**Consultation Response from
KC Waste Strategy (Refuse & Cleansing)**

PA no. & address: 2020/92546 Land off, Blackmoorfoot Road and Felks Street, Crosland Moor, Huddersfield, HD4 7AD

Date Responded: 27/8/20	Responding Officer: Carol Oakden	Responding Ref: WPS-20-026
-----------------------------------	--------------------------------------------	--------------------------------------

1.18 ILLUSTRATIVE MASTERPLAN

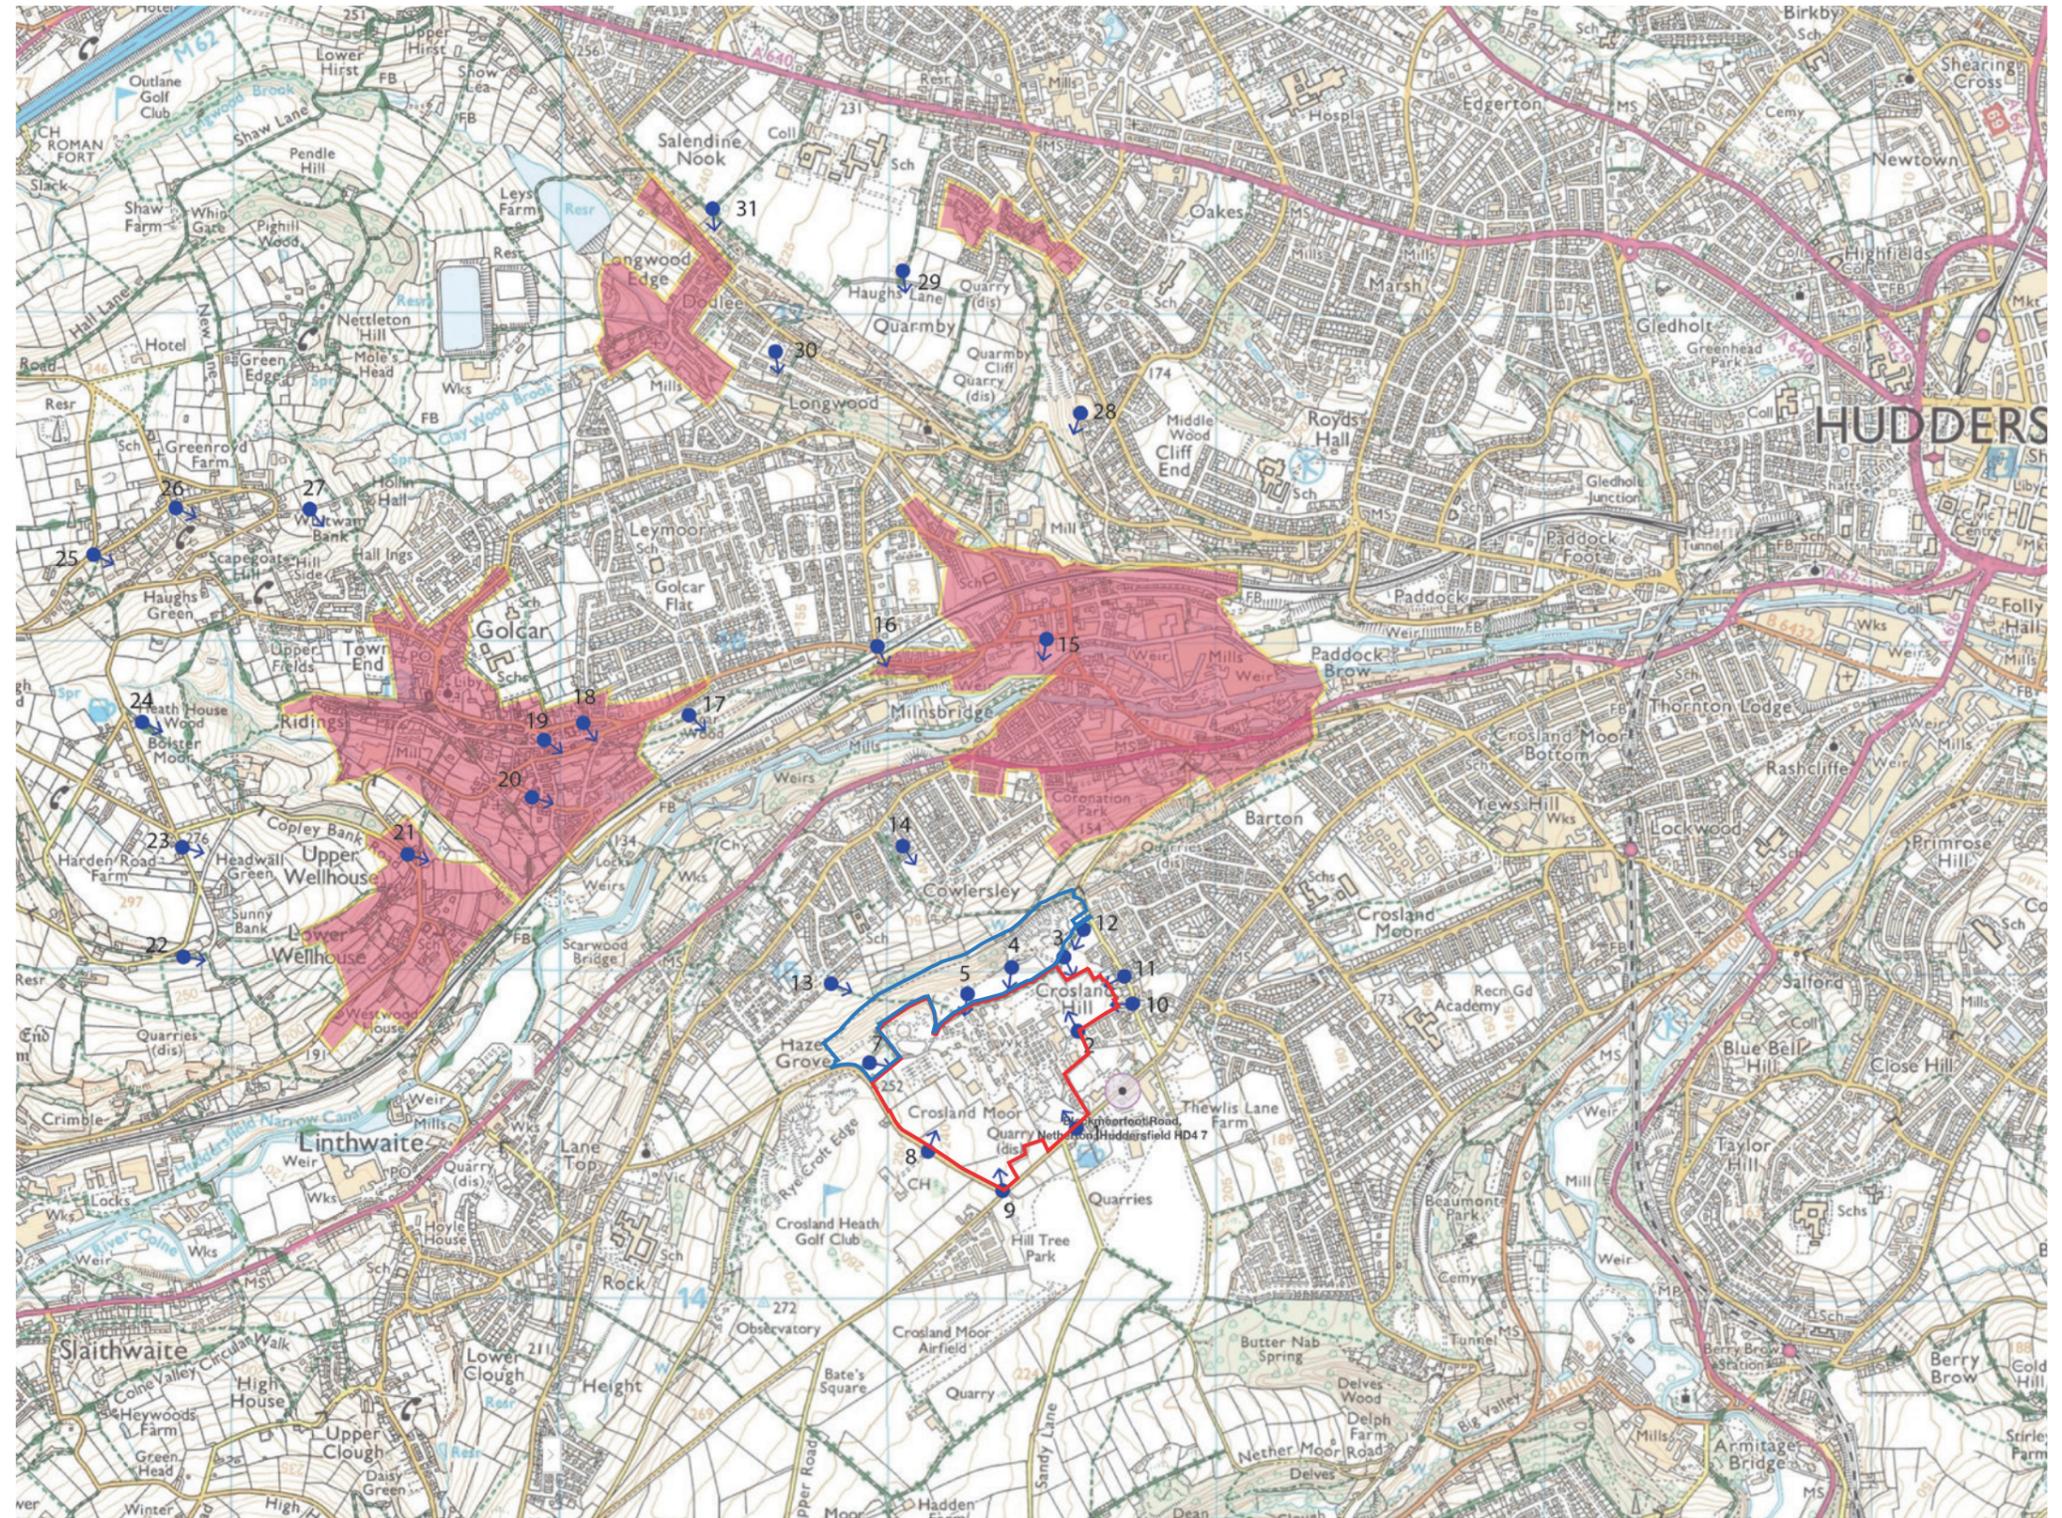
- Cul-de-sac road layouts must be avoided to reduce the need to reverse an RCV. The concept layout for this site shows multiple cul-de-sacs – these present a serious issue for RCVs by requiring unnecessary reversing, often exacerbated by inadequate turning facilities or parked cars in turning heads. Looped layouts should be pursued through to detailed design if the outline application is approved. All layouts will require demonstration (by swept path analysis) that an 11.85m refuse collection vehicle can safely manoeuvre into/out of the access points and around all turnings. Legislative changes coupled with housing growth will put pressure on the Council to utilise bigger, more efficient vehicles and the need to accommodate these safely, with minimal reversing is vital.
